From: Jean Fraser
To: Silas Canavan
CC: Audra Wrigley; Barbara Barhydt; Evan Carroll
Date: 2/10/2016 2:53 PM
Subject: Key questions for discussion RE: Mtg confirmed: 9am Thurs 2.11.16 RE: 88 Preble Street meeting

From: Jean Fraser [mailto:JF@portlandmaine.gov]
Sent: Monday, February 08, 2016 12:18 PM
To: silas@walsh-eng.com
Cc: Barbara Barhydt <BAB@portlandmaine.gov>
Subject: 88 Preble Street meeting

I am the Planner coordinating the review of the proposed Salvation Army addition.

**CONCEPT DRAWINGS  
 NOT FOR CONSTRUCTION**  
**EAST ELEVATION**

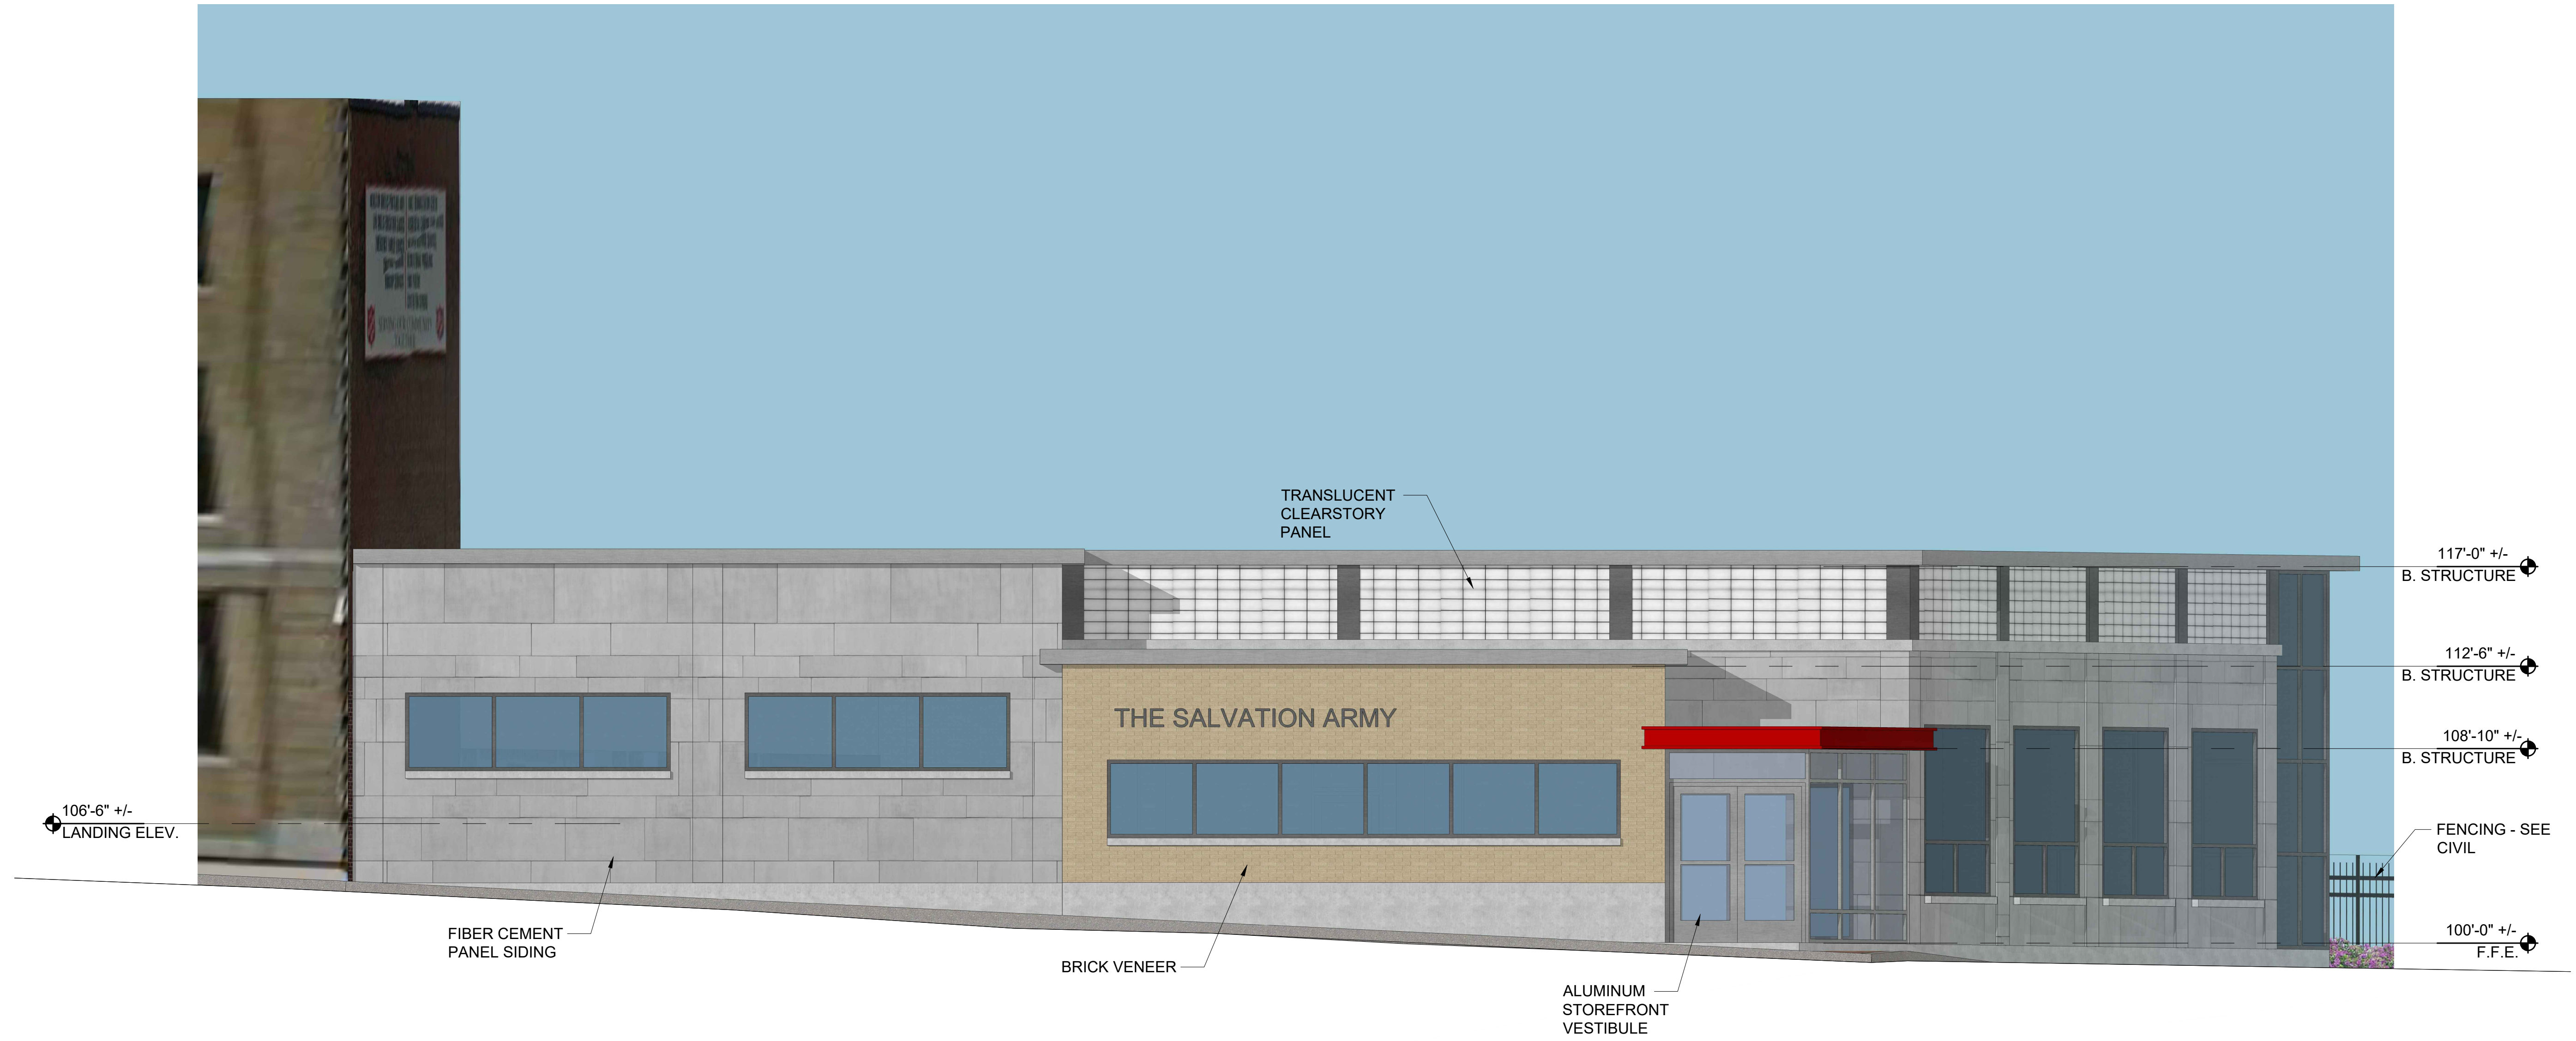
- 4. Uses:** What use is going into the space vacated by the cafeteria/kitchen; who will be using the new entrance on Alder Street?
- 5. Snow and Ice loading and removal:** It appears snow is going to slide onto abutting property (?alley appears to be on abutters land)....rights? removal? Elevation does not show the roof sloped.
